# LOT 1 WOODMEN HILLS FILING NO. 12

Sheet Title:  
**SITE PLAN / COVER SHEET**

# Site Development Plan\_V2.pdf Markup Summary

8
Of 8

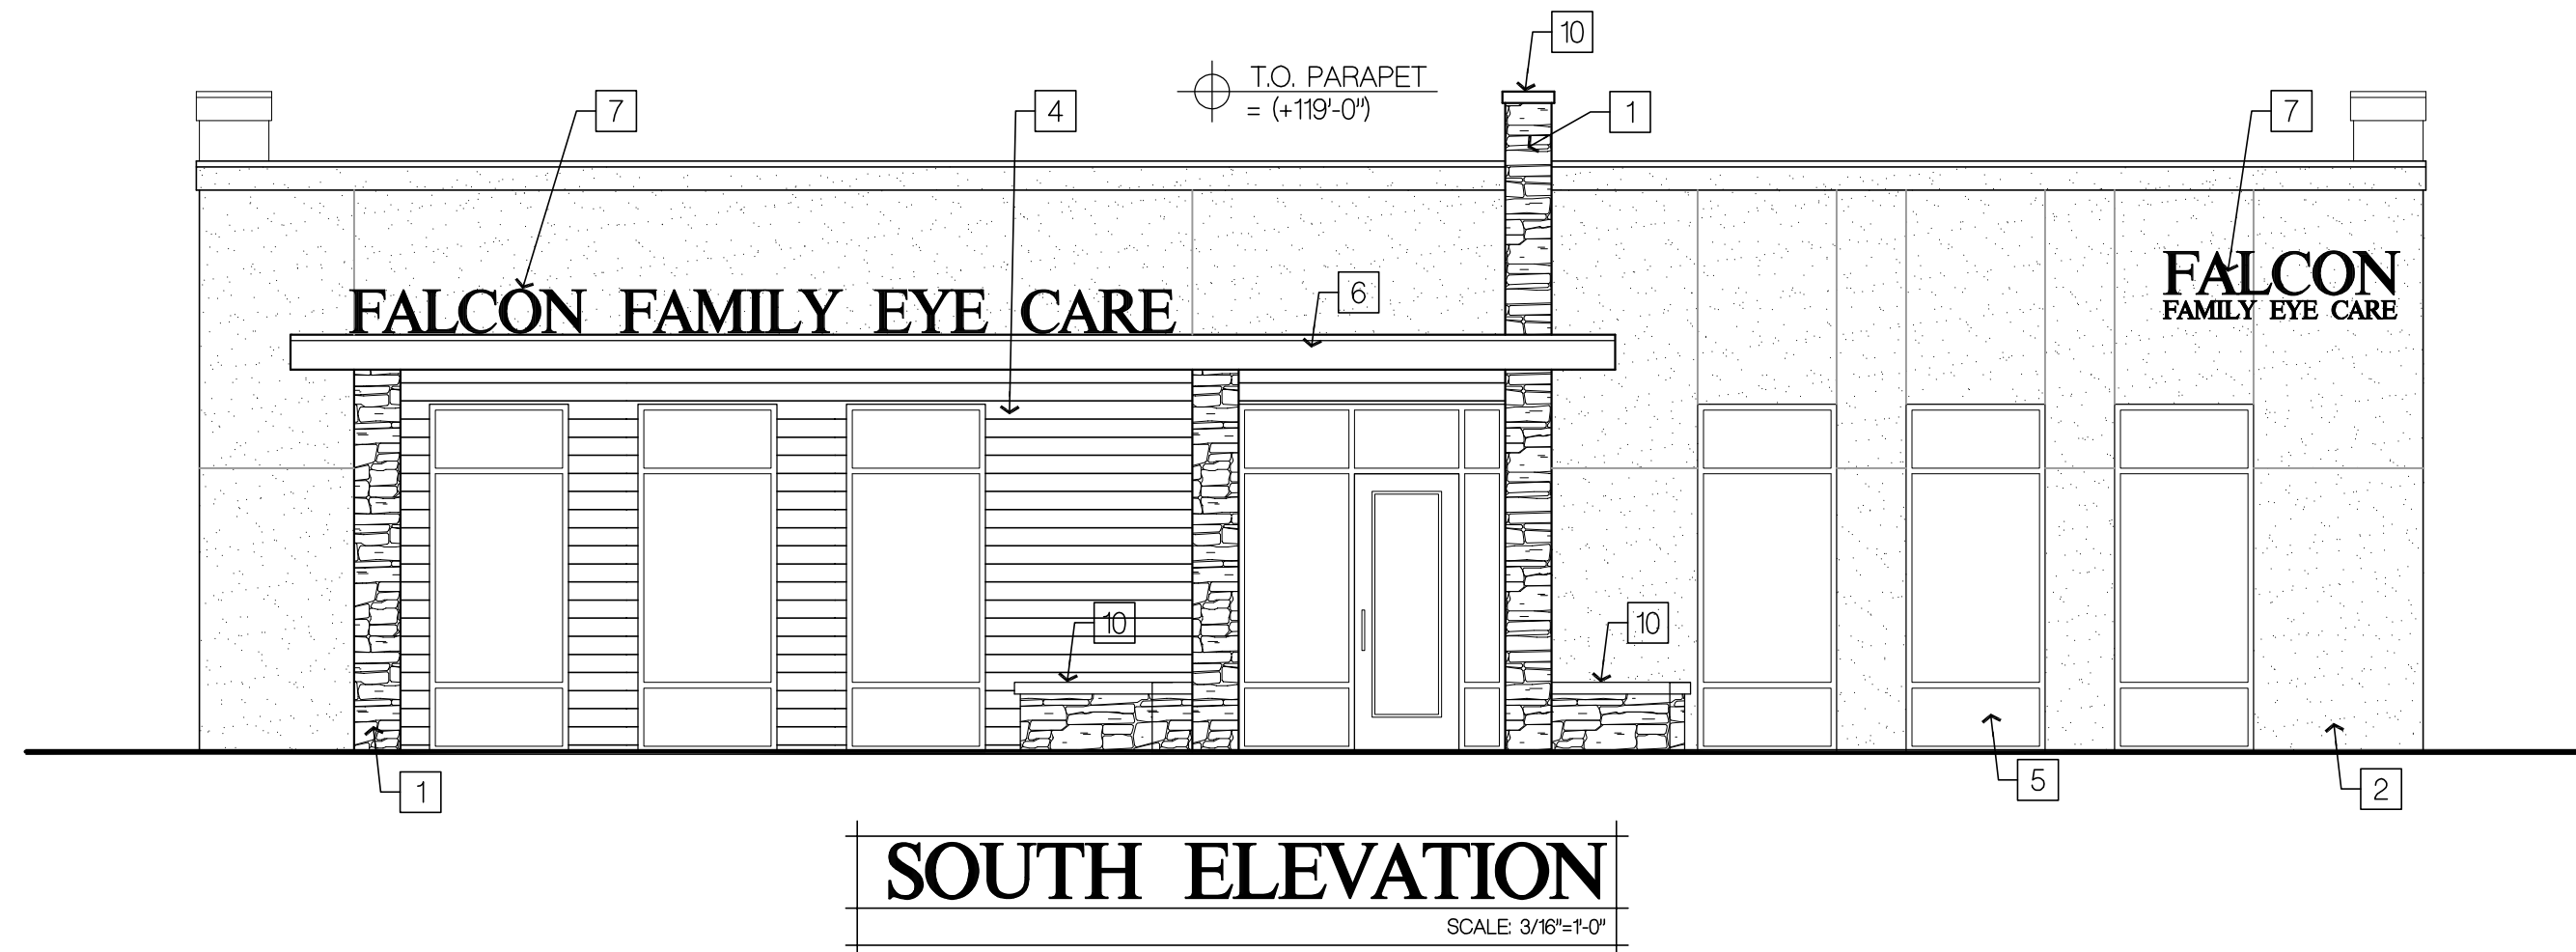
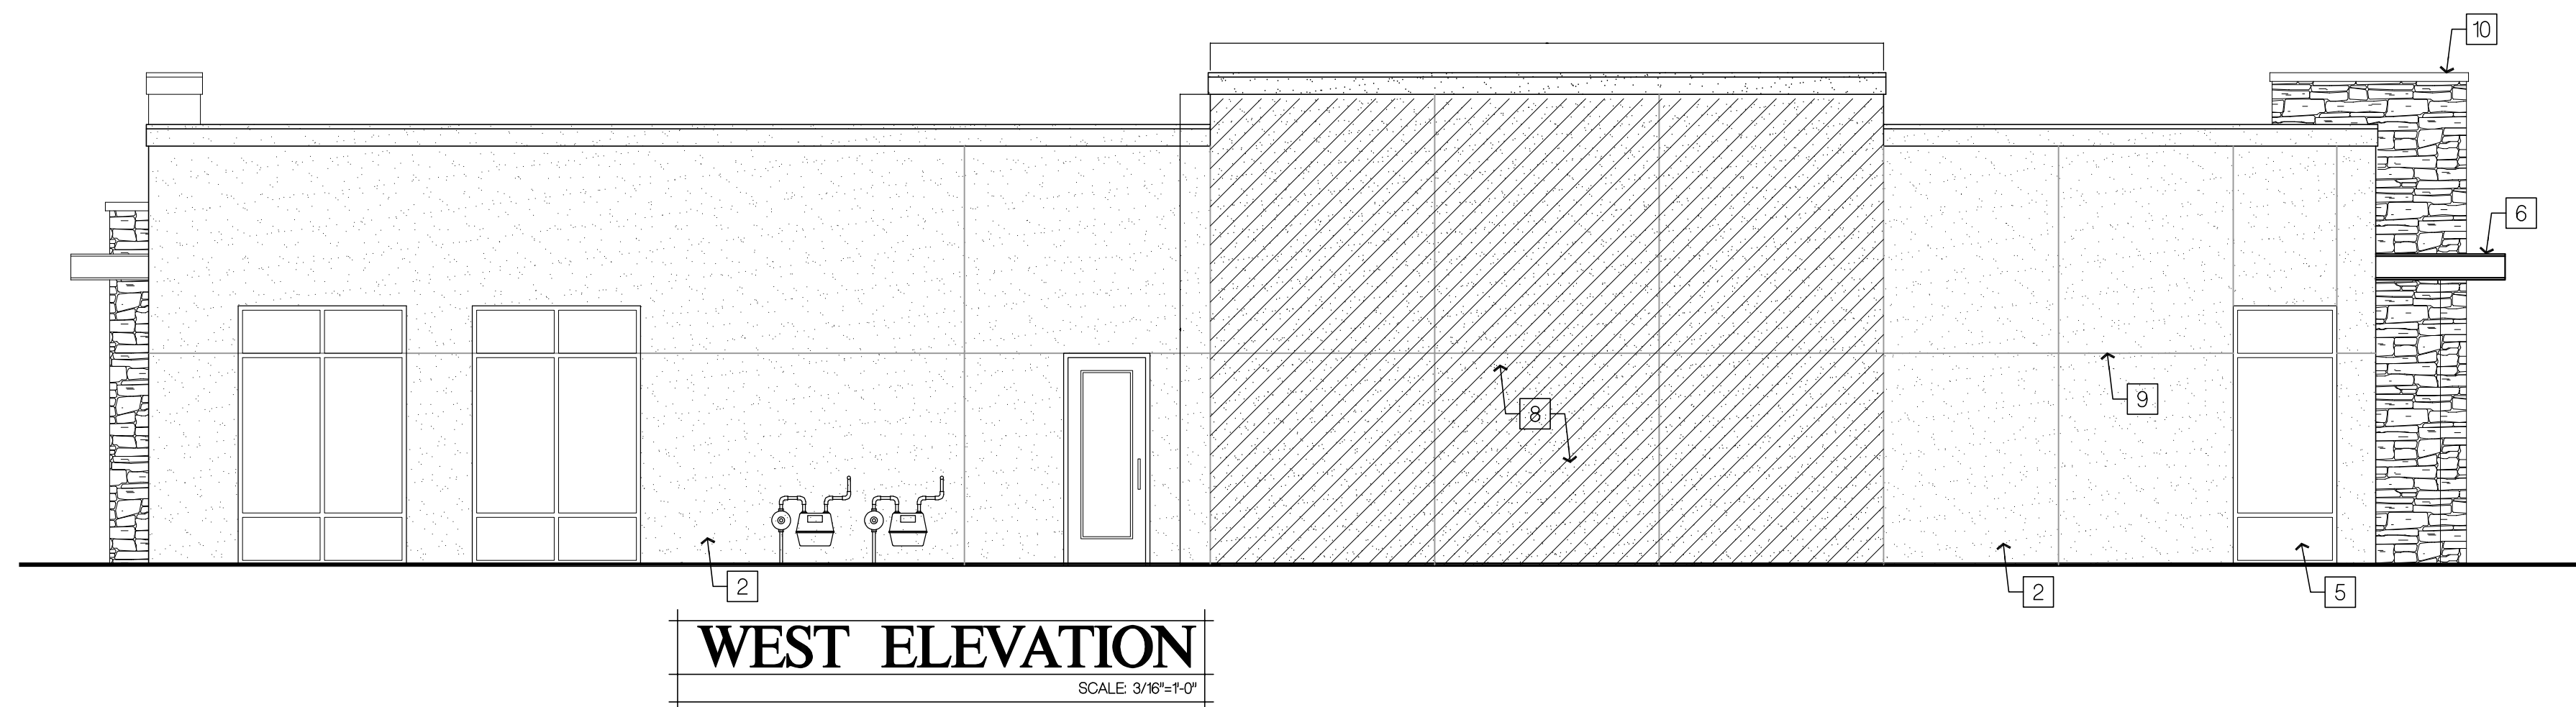
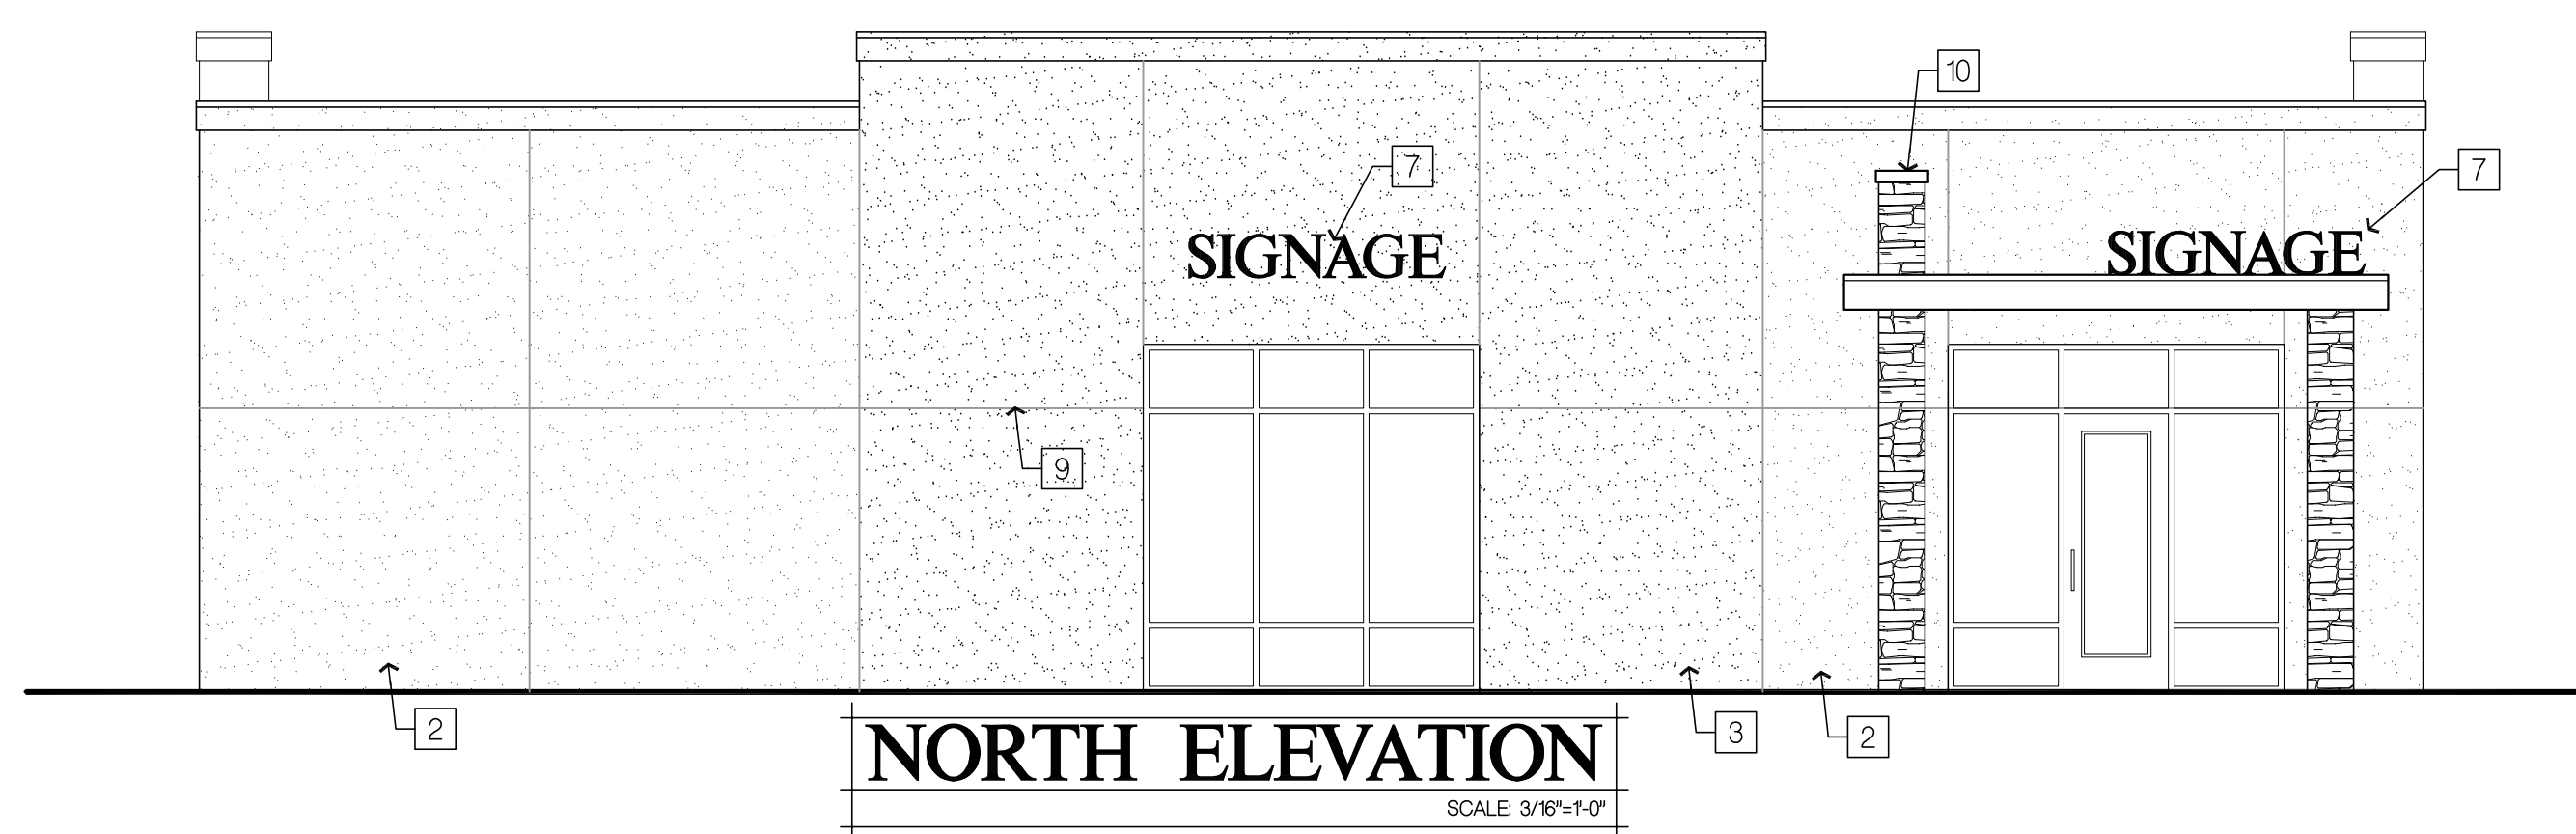
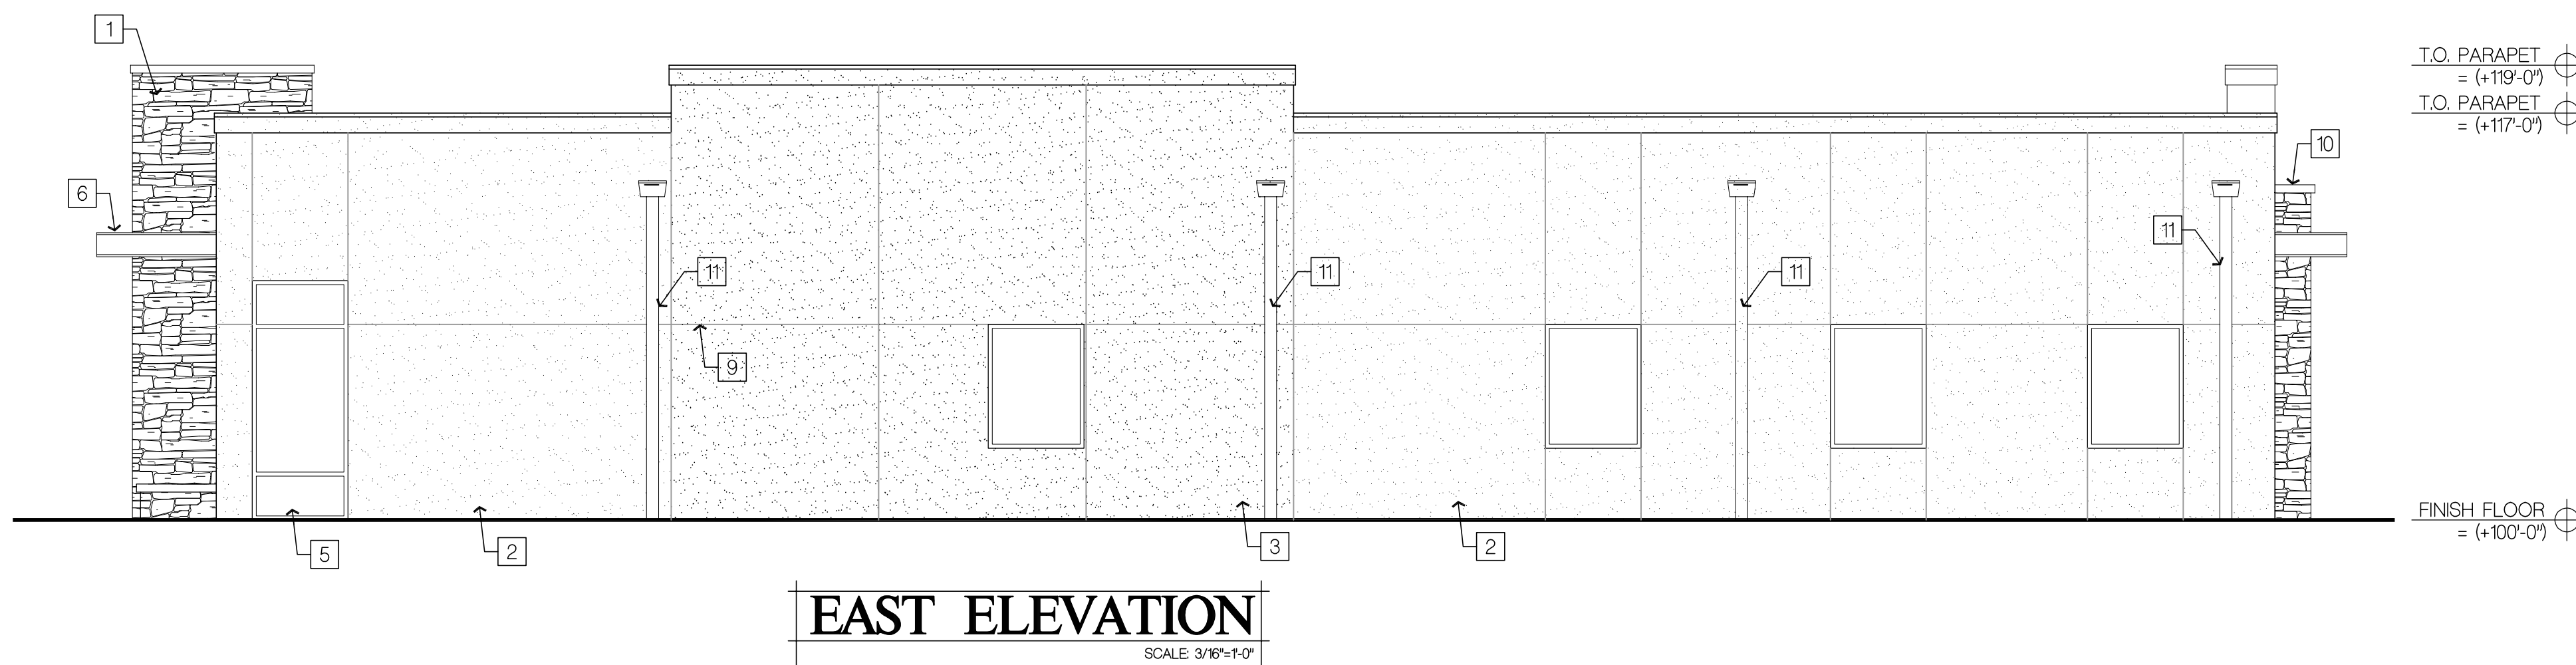
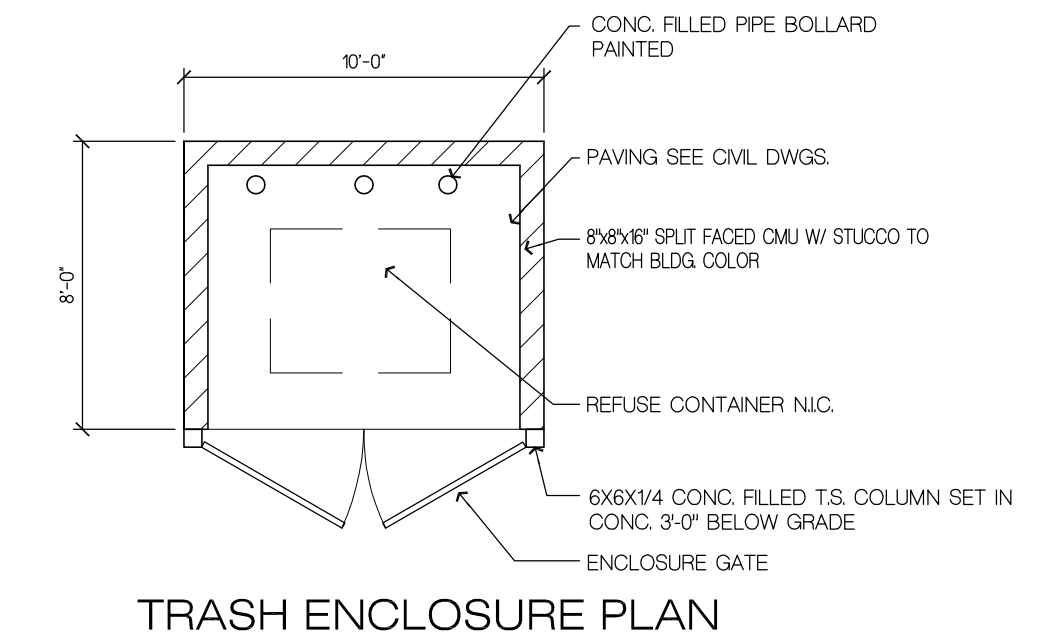
Please refer to the trash enclosure detail on the elevations sheet (sheet 8):

"proposed trash enclosure, refer to Elevations Plan Sheet 8"
